## KITTTITAS COUNTY COMMUNITY DEVELOPMENT SERVICES

RE: *SV-14-00001 Via Kachess – Request for additional information*

STATE OF WASHINGTON  
DEPARTMENT OF ECOLOGY

RE: Kittitas County Permit SV-14-00001  
Richard Landen - Applicant  
Incomplete Shoreline Variance Permit Ecology #VAR-282

DATE: June 12, 2014
 SHEET: 1401
 PROJECT: VAR1
 SITE PLAN

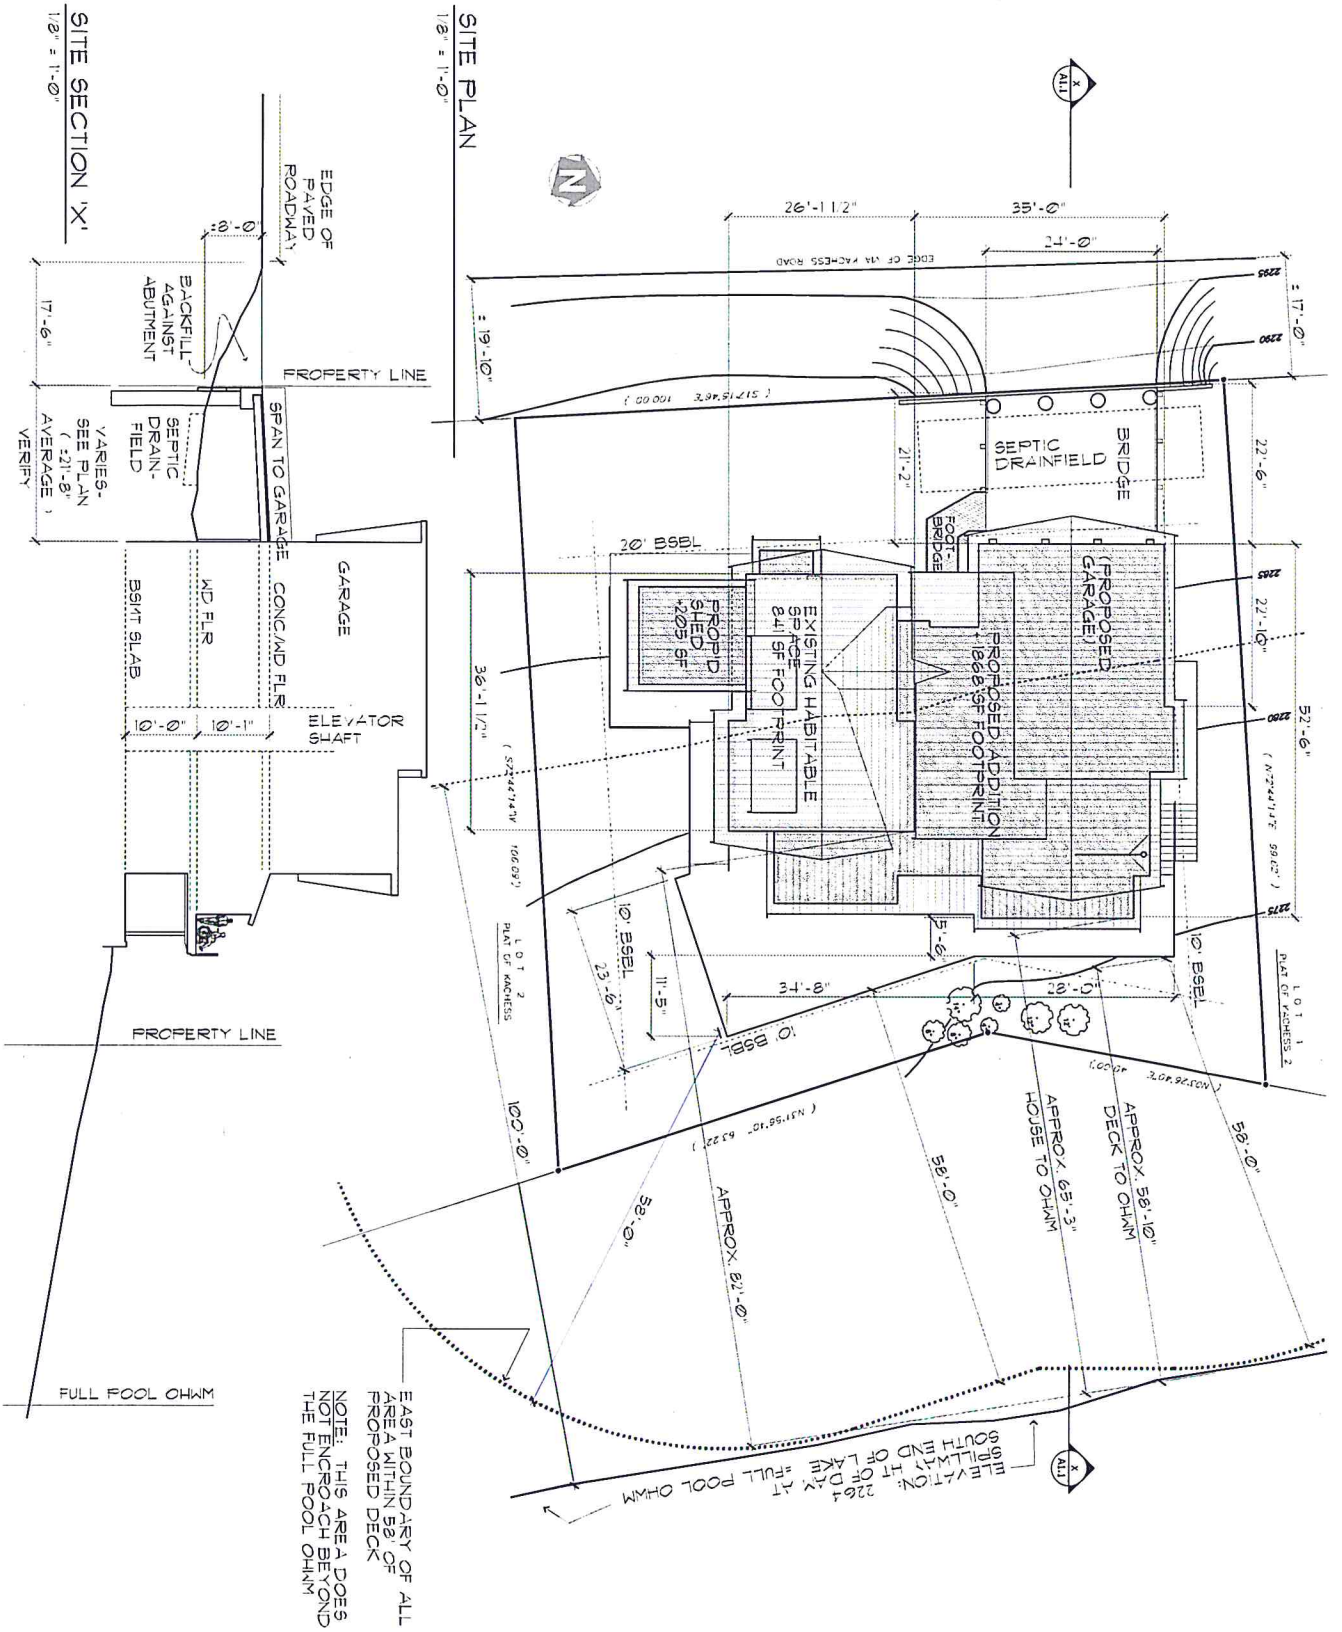
On July 17, 2014 the Department of Ecology (Ecology) received the Kittitas County decision on the subject Shoreline Variance Permit to expand an existing residence to within 58 feet of the Ordinary High Water Mark (OHMW) of Lake Kachess. Expansion will include construction of a garage with bridge deck span for entry from Via Kachess Road, handicapped living space, storage shed, and widening of the existing deck waterward at least 12 feet or more (not clear from submitted plans so far).

- A clear drawing of the additional deck area. The drawing should include dimensions of the deck expansion.

PARTIAL MAIN FLOOR PLAN
 1/4" = 1'-0"

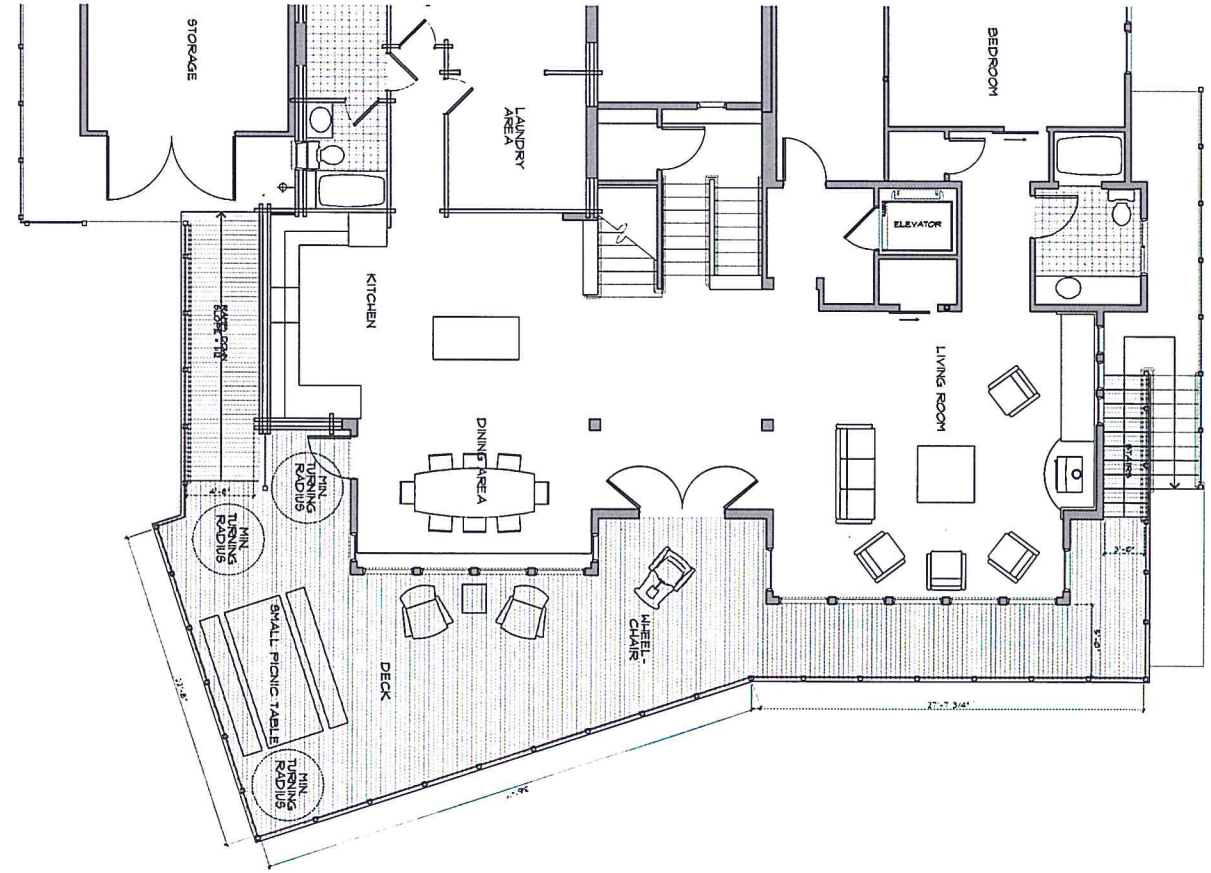
- A narrative which discusses the proposed deck expansion dimensions, and how those dimensions are the minimum necessary to afford relief for handicapped access. (The Shoreline Management Act (SMA) provides clear language that variances or intrusions into setback areas are granted for only that amount that is absolutely necessary to make the project (deck) functional. The turning radius of the wheelchair and any ADA standards for width would be important information to evaluate the need. If the deck can be designed to be smaller in width and still meet the needs of the applicant, then a new drawing of the deck footprint should be submitted in response to this letter.
